MEMORANDUM

Re: Conformance of the Updated Site Plan to the Geotechnical Report, 1305 Maritime Way

Ottawa, Ontario

**KANATA HAMPTON
INN & SUITES**

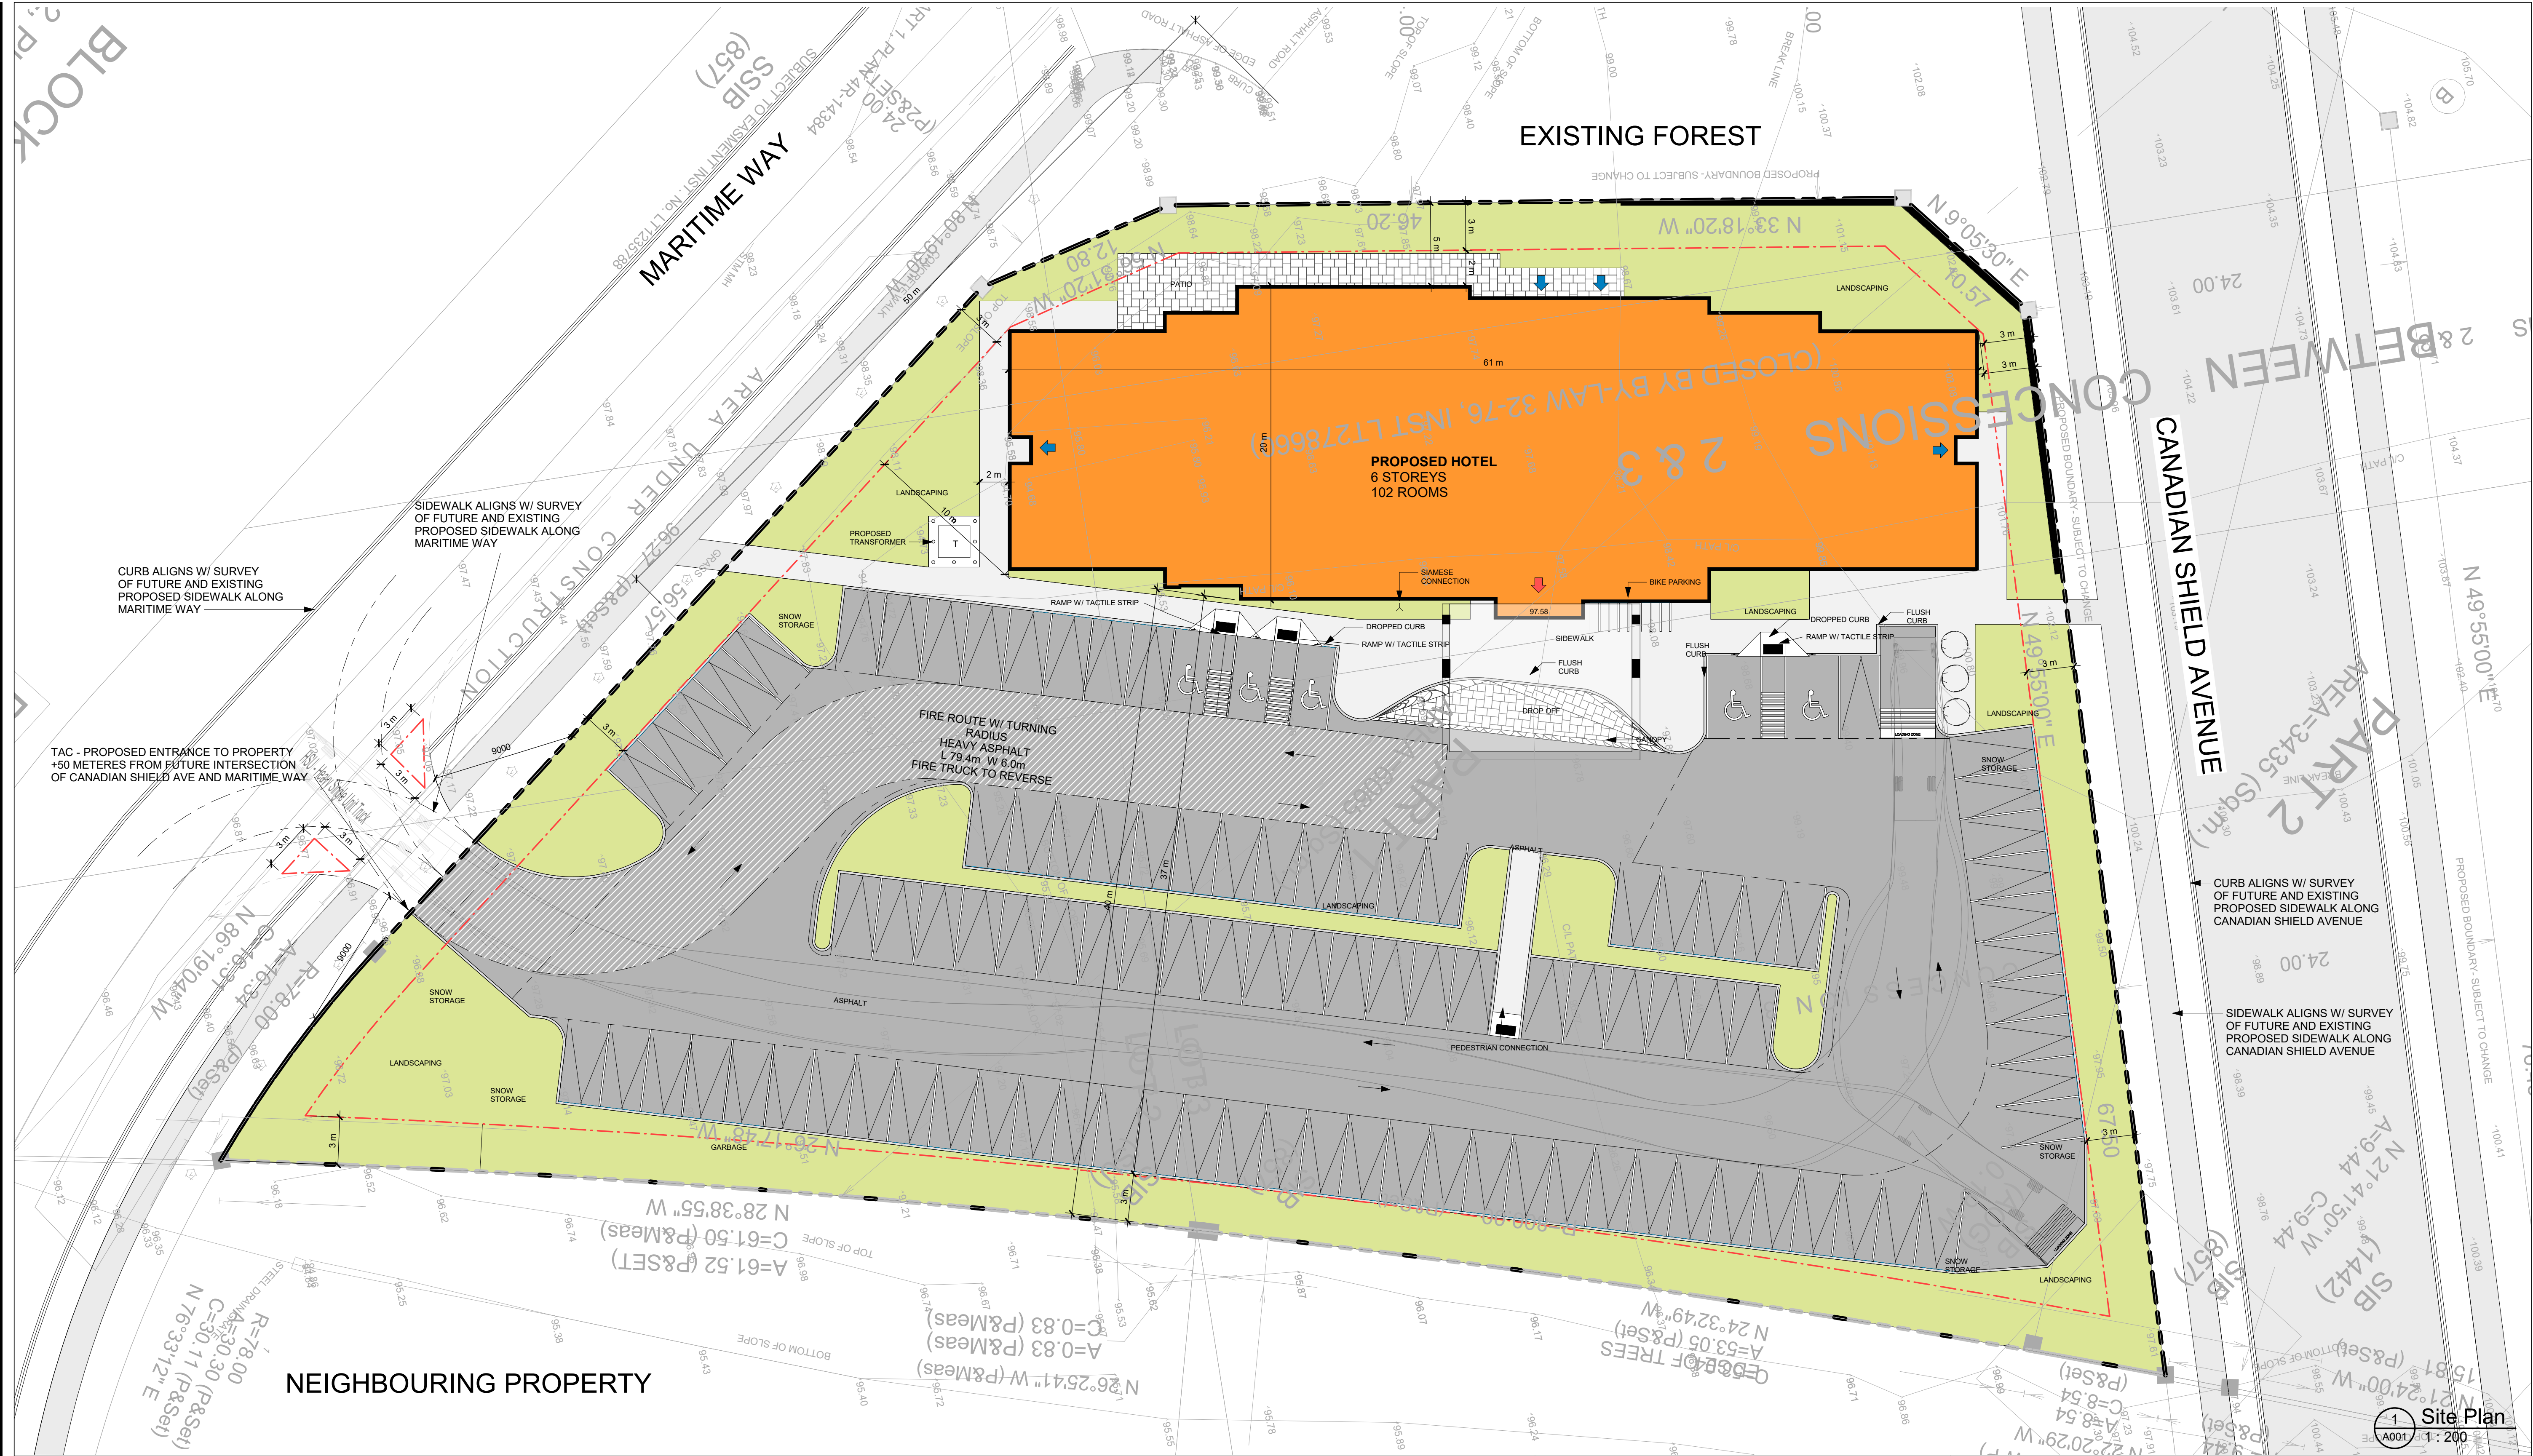
Our team received the recently updated Site Plan dated November 5, 2021, issued for the permit. This site plan was reviewed, and minor variations were observed in comparison to the previous site plan. However, the changes are minor and there is no conflict with the recommendations noted in the geotechnical report. All recommendations pertaining to foundation design, structural design, pavement and sidewalks construction, landscaping, etc. are valid and applicable to the recent site plan.

Since all foundation systems, deep or shallow will be bearing on rock, the structural function is independent of the settlements induced by the proposed fill. It is understood the final finished floor may be up to 0.5 m higher than what was initially assumed in the Report. This variance is acceptable. Recommendations included in Section 8 of the Report shall be followed for fill placement.
